**MODIFICATION REQUEST:
FERN BAY SEASIDE VILLAGE
SEASIDE BOULEVARDE, FERN BAY
06_0250 MOD 5**

Director-General's
Environmental Assessment Report
Section 75W of the
Environmental Planning and Assessment Act 1979

April 2014

DRAWING TITLE
STAGE 7 DETAIL PLAN REV-F
DEVELOPMENT
PROJECT PLAN F
FERN BAY SEASIDE VILLAGE
NELSON BAY ROAD, FERN BAY
CLIENT
RAWSON COMMUNITIES PTY LIMITED

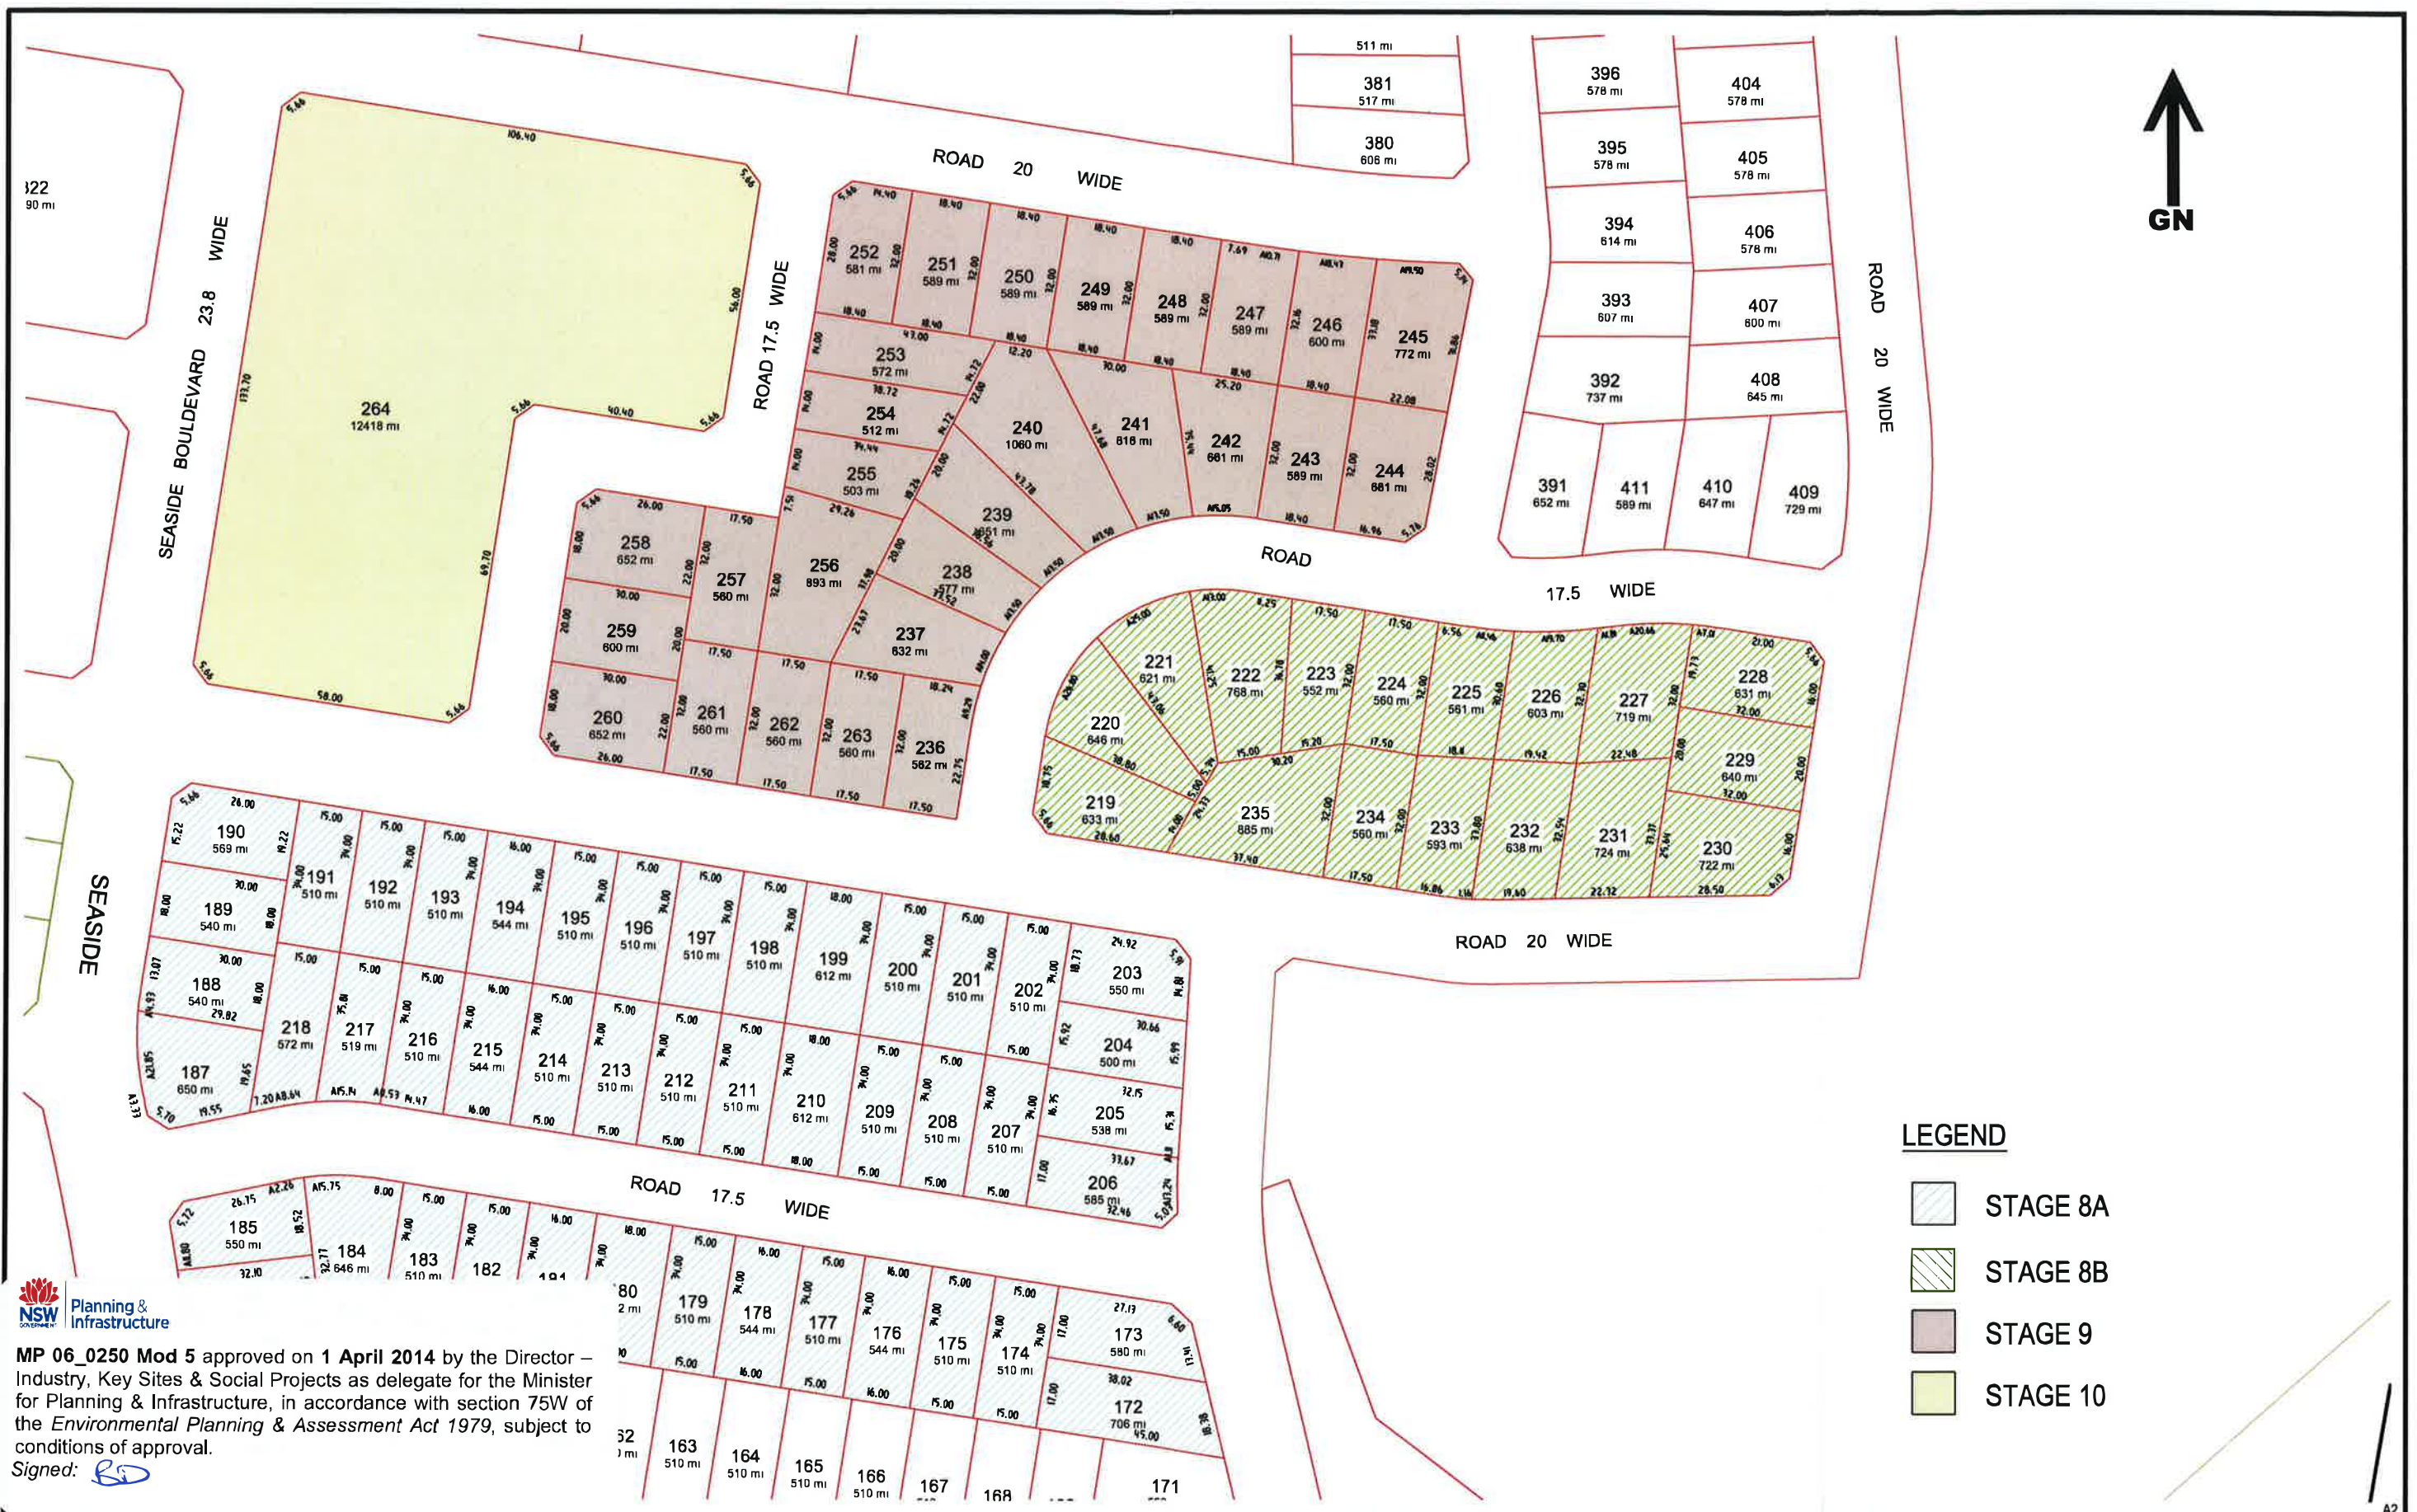
The size and configuration of residential lots approved under Stages 5 to 8 are proposed to be amended slightly. Those lots within Stages 5 & 6 are proposed to be shifted marginally to the north. The proponent advised that the minor variations to the shape of some residential lots will improve the constructability of dwellings on these lots. The proponent further advised the amended subdivision design will provide safer intersection alignments within Stages 5 & 6 from the approved 'Y' intersection configuration to a safer 'T' intersection.

The proposed modification to the subdivision layout does not result in the creation of any additional lots, and the urban footprint will not expand beyond what was originally approved. The revised intersection alignments will also provide for the safer movement of traffic within the subdivision due to improved sight distances. The agency, therefore, raises no concern in regards to this aspect of the modification.
